TfNSW Reference: SYD20/01438/03

DPIE Reference: SSD-11802230

**EXHIBITION OF EIS – STAGED CONSTRUCTION OF SYDNEY OLYMPIC PARK HIGH SCHOOL - 7 - 9 BURROWAY ROAD, WENTWORTH POINT**

Figure 5-9 Waste access

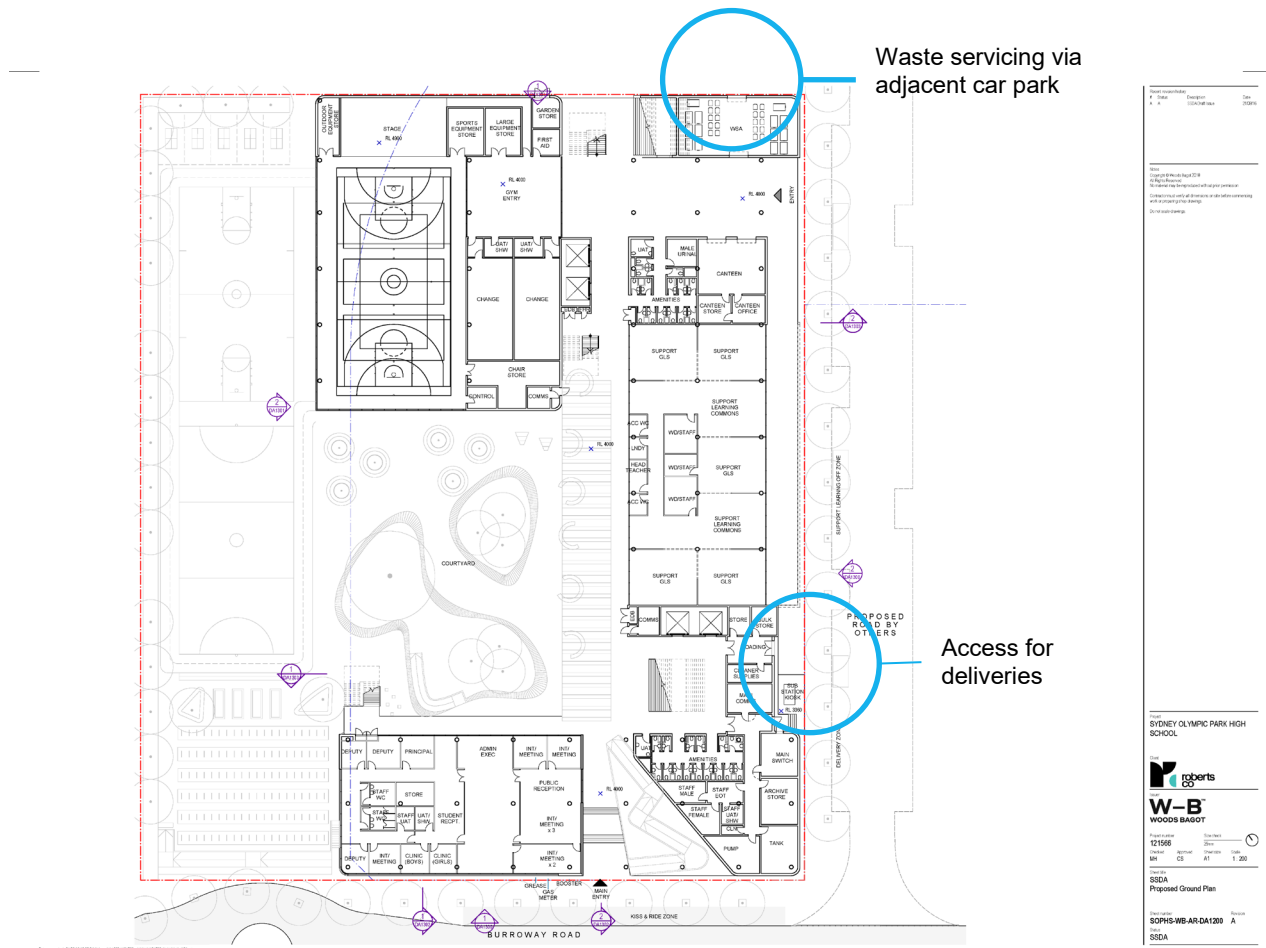
4. It is noted that the Transport Impact Statement states that “servicing and waste collection will occur along the future eastern road (delivered by others) with direct level on-street access to the storerooms. It is expected the eastern road will be completed prior to commencement of school operations. Waste collection is discussed in further detail at section 7.15 of this EIS.” In the instance that the eastern road is not delivered a back-up plan has not been presented.

It is requested that the applicant presents alternate options for loading and servicing in the instance that the future eastern road is not delivered in time for the commencement of school operations.
